CITY OF PORTLAND, MAINE

Project Name: Six Units to Ambassador
Address: 37 Casco Street
Applicant: Ambassador, LLC
Planner: Shukria Wiar

Project ID: 2017-144
CBL: 037 D007001

CONVERSION OF STORAGE SPACE INTO SIX APARTMENTS

Subdivision Plat
Made For
Ambassador, LLC
Northeastly Sideline Of Casco Street
Portland, Maine

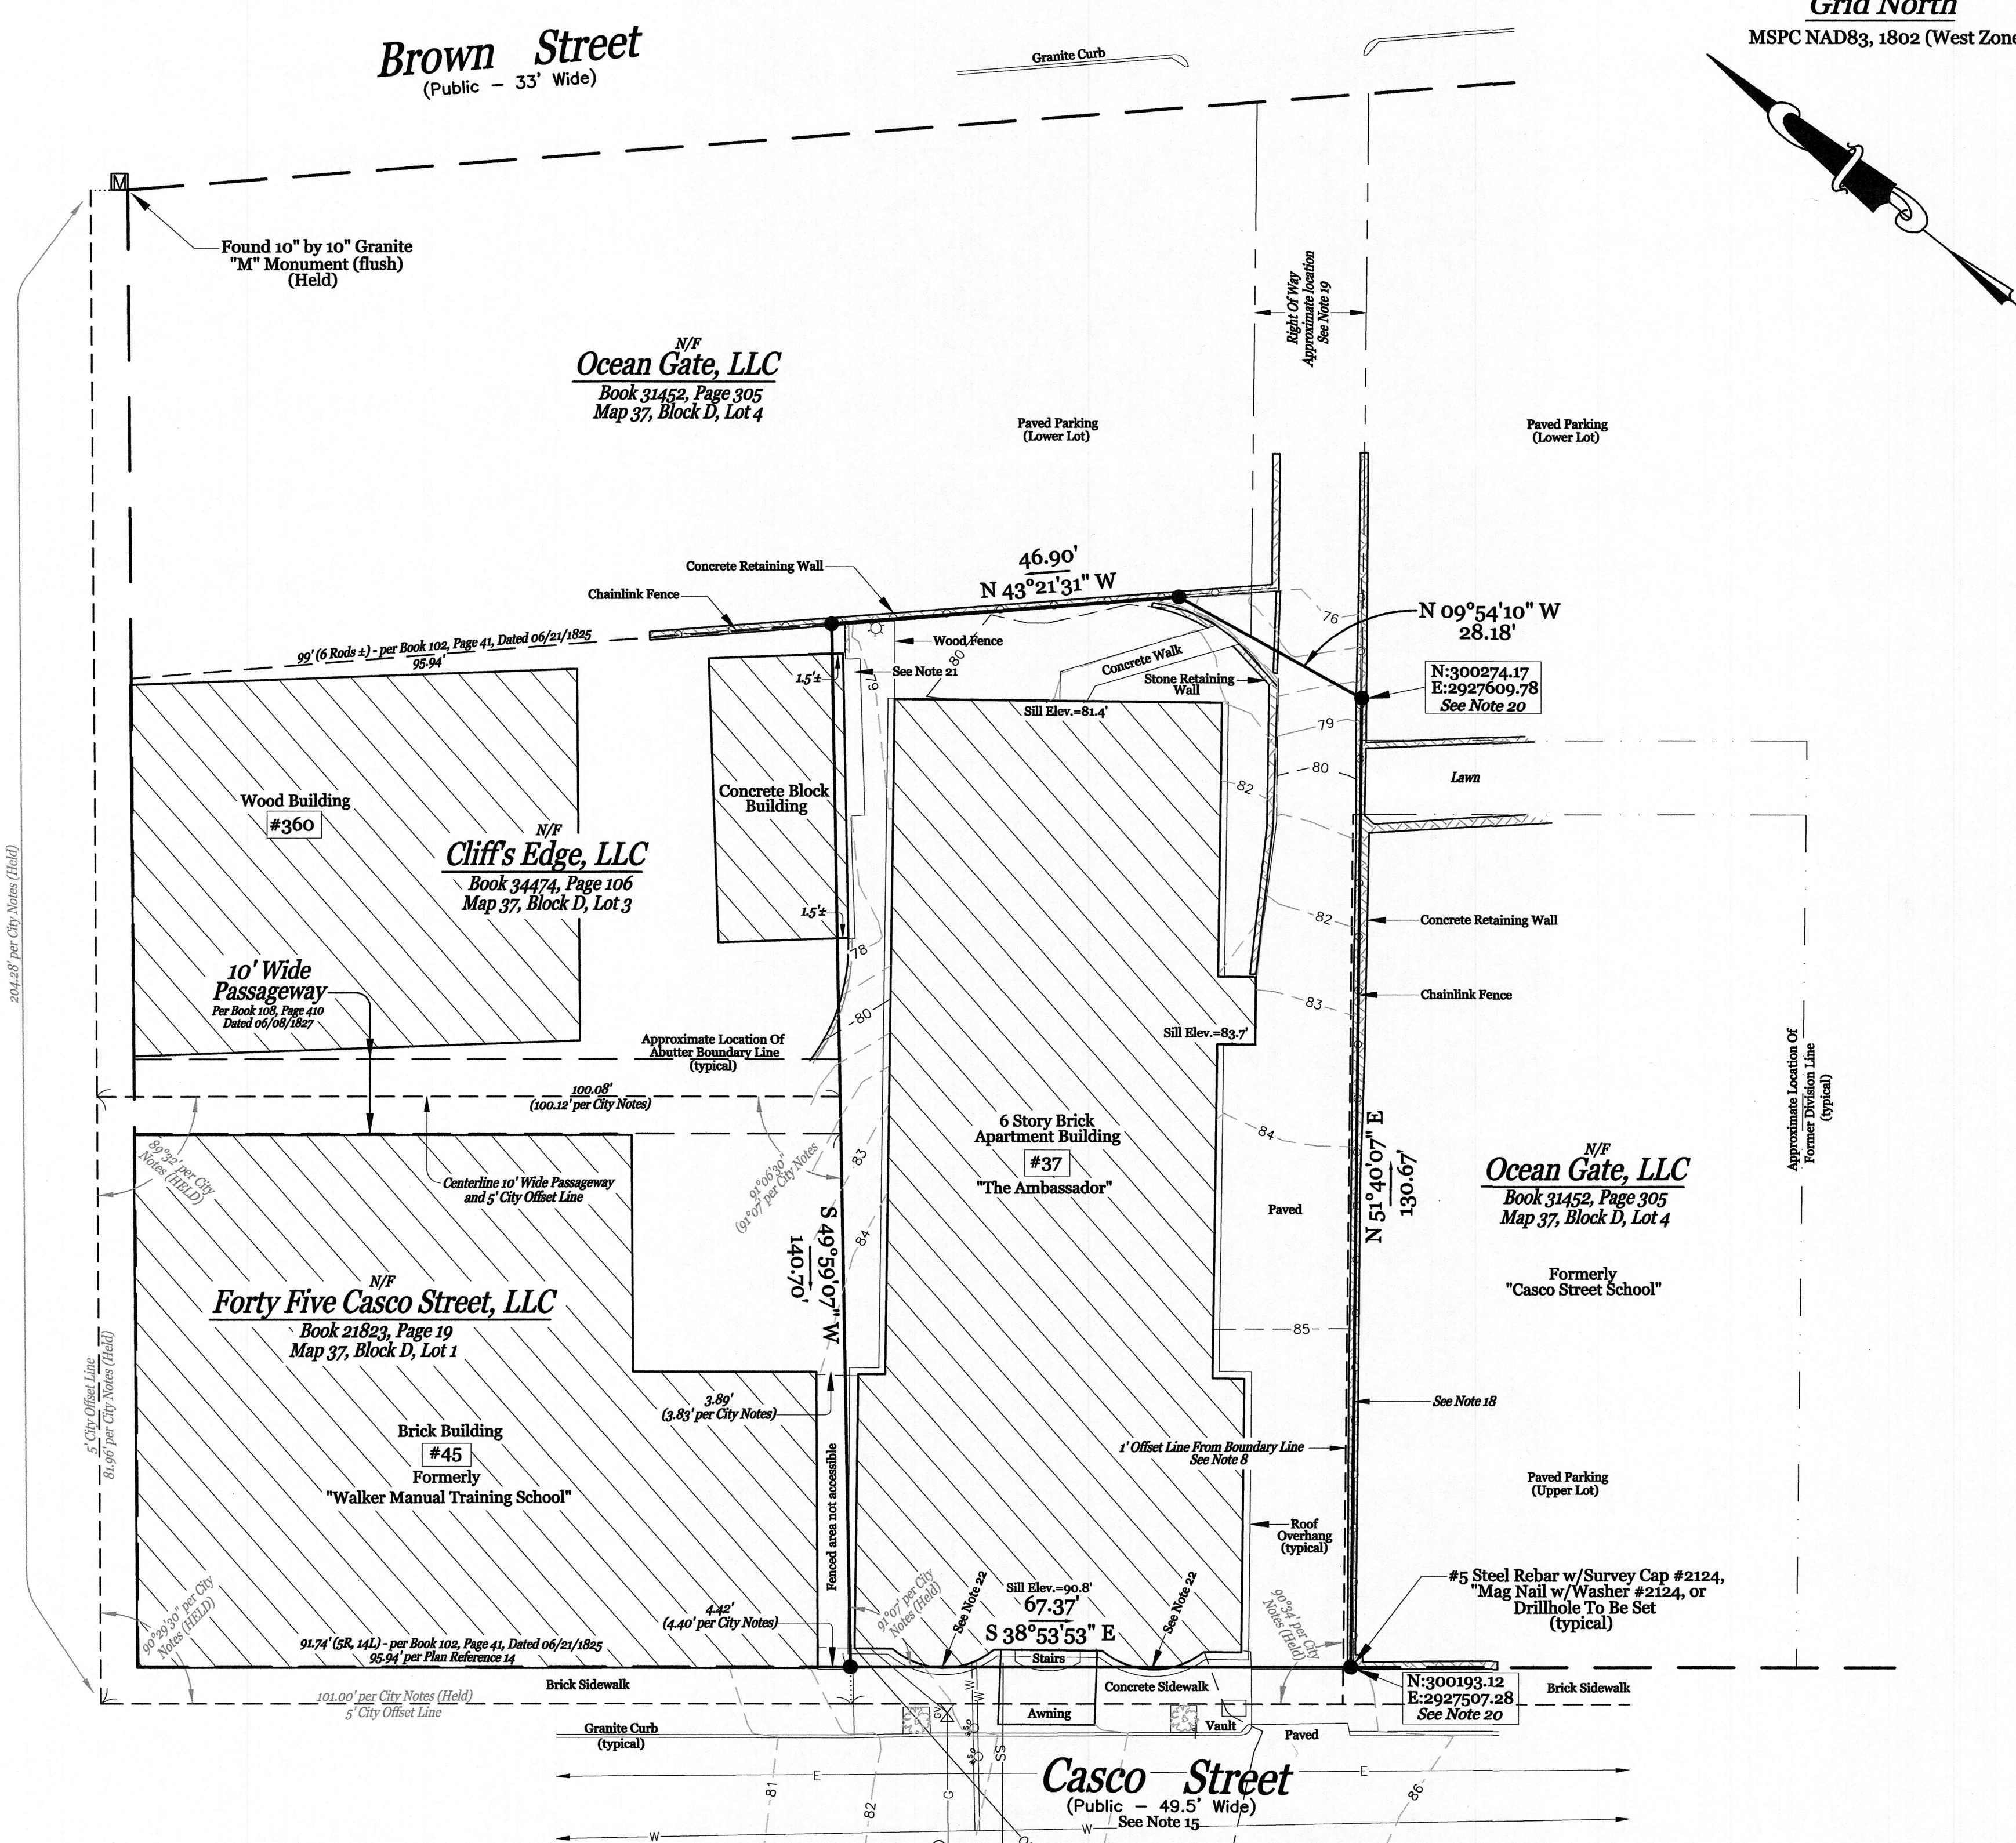
The subdivision plat has been reviewed by staff. The plat will need to show the zoning information for the zone and identify that the parcel is within the Congress Street Historic District. The plat will also need to show the uses of the building, the number of residential units (existing and proposed), and the number of parking spaces on site.

1. The recording plat shall be revised noting all zoning information, number of units, waivers, and conditions for review and approval by the Planning Authority prior to recording. All waivers shall be recorded within 90 days of the Planning Board approval.
2. A bicycle rack meeting the city's specifications in the technical manual shall be installed prior to the issuance of a certificate of occupancy. The location of it will be determined on site.
3. A contribution amount of \$2,000 to the City's Street Tree Fund to be substituted for the provision on site of five of the required street trees prior to a building permit.
